**Dargues Reef Gold Project Modification 3 (MP 10_0054 Mod 3)
Comment on the Response to Submissions Report**

Dargues Reef Gold Project Modification 3 (MP 10_0054 Mod 3) Comment on the Response to Submissions Report DPI Water - Detailed Comments

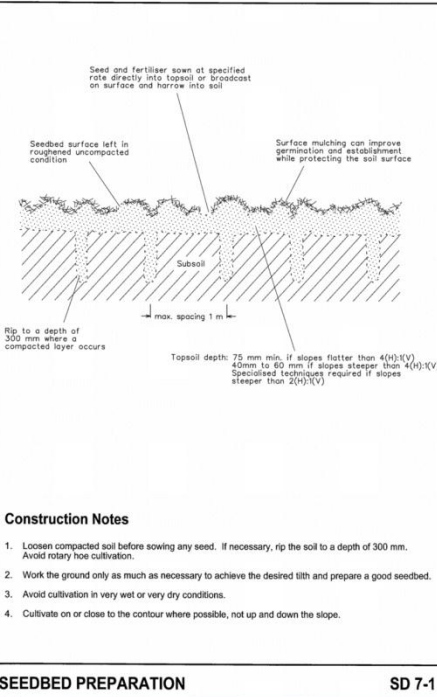
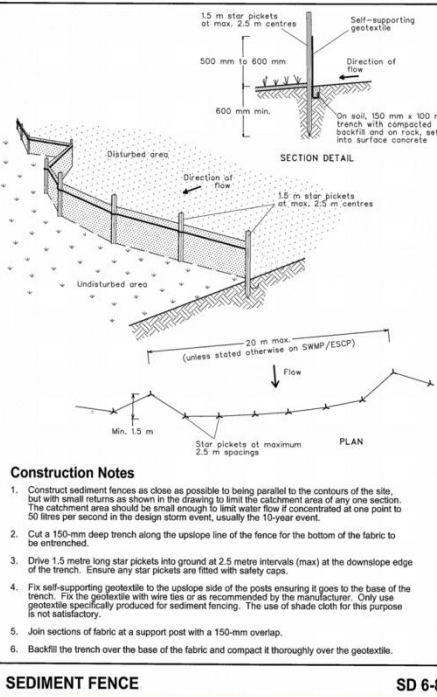
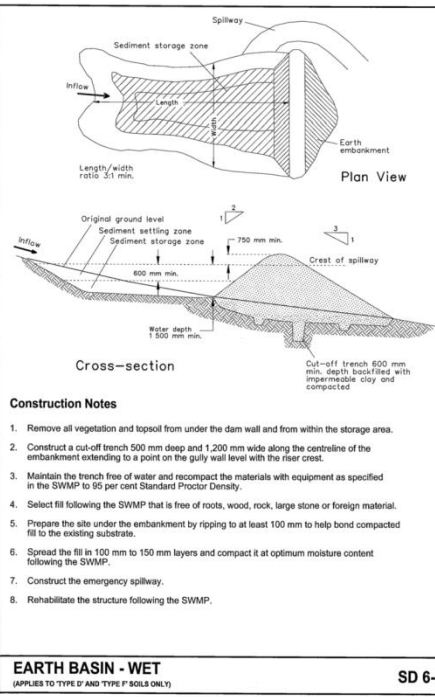
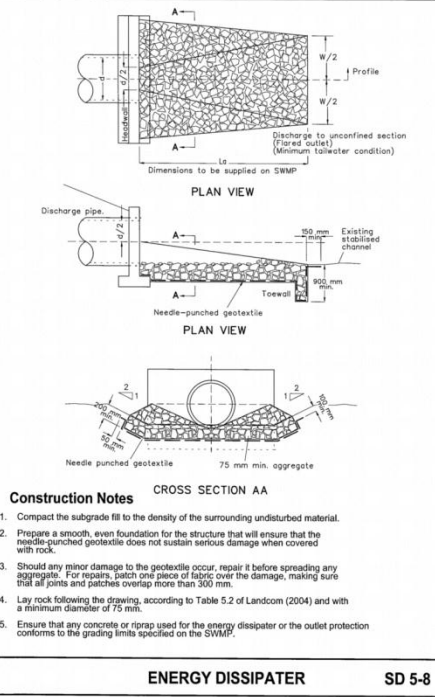
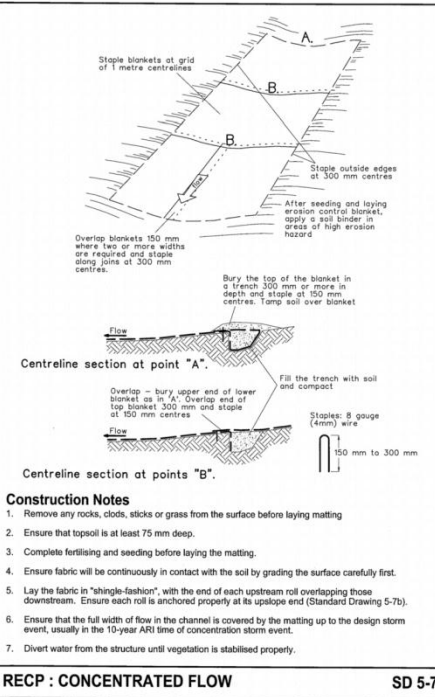
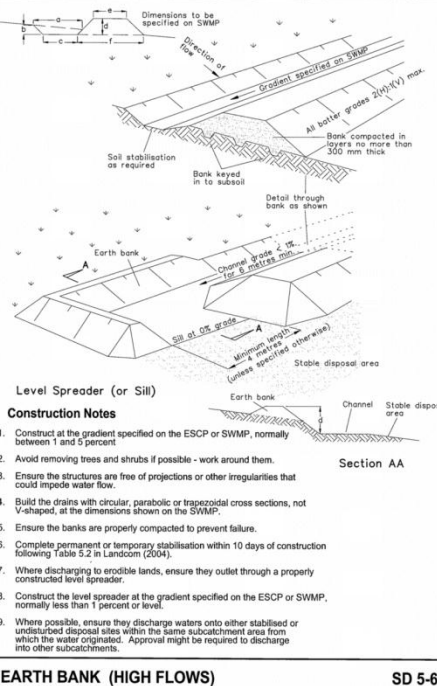
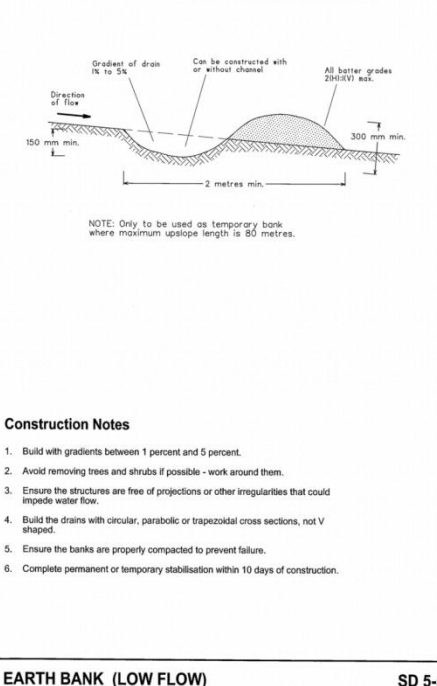
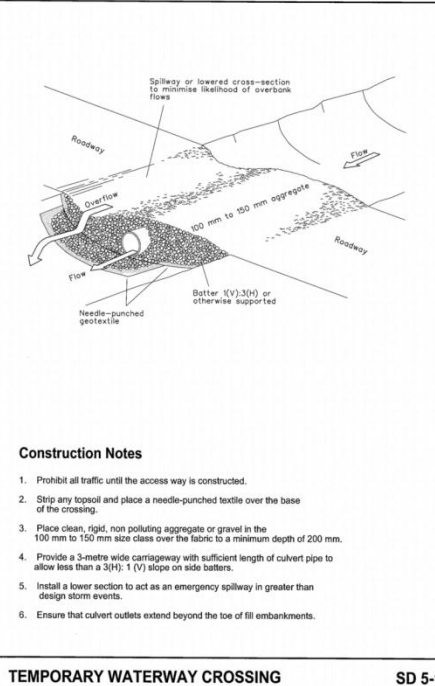
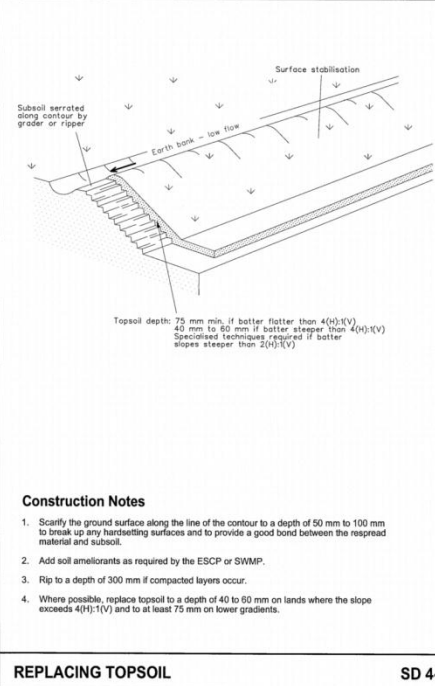
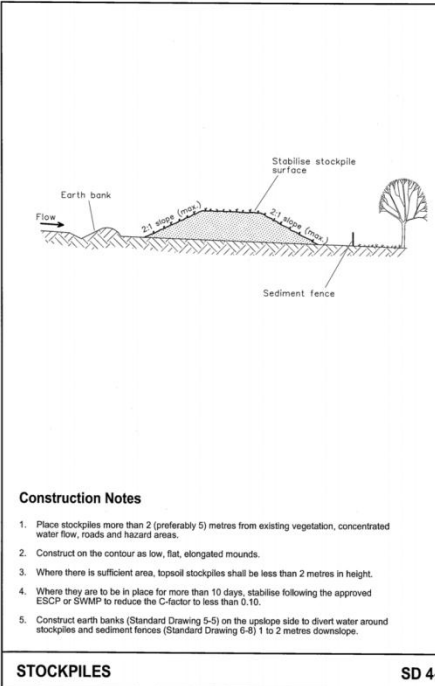
1. There is a commitment to incorporate the use of ERSED controls to the standard outlined in the "*Managing Urban Stormwater: Soils and Construction*" publication. However, this is an industrial mine site and these standards are unlikely to cope with the challenges presented by heavy rainfall across the mine site. While the design principles underpinning these guidelines are probably universally appropriate, the performance standards for an industrial mine site need to be significantly higher. The Environment Protection Authority should ensure that a high level of sediment and erosion control is incorporated into this proposal.

2. The design criteria for ERSED controls has been based on a 5 day 85th percentile rainfall event of 44 mm. According to advice provided by the Environment Protection Authority a rainfall event of 44mm is approximately a 1 in 1 year 5-6 hour ARI event. Essentially this means that the erosion and sediment controls would be overwhelmed once every 12 months on average. This is unacceptably high given the importance and value of downstream

aquatic habitats (including the Batemans Marine Park). On page 24 the applicant states "...the proponent has committed to ensuring that there would be no controlled discharges to natural drainage from sediment basins during the life of the project". This is somewhat misleading as the adopted ERSED design rainfall event would result in frequent *uncontrolled discharge* to natural drainage at this site. Therefore, the value of 44mm is too low and does not adequately address the risk of sediment discharge to natural waterways during heavy rainfall events. DPI recommends that the ERSED design criteria should be based on a much greater rainfall event (such as 100mm/24 hours).
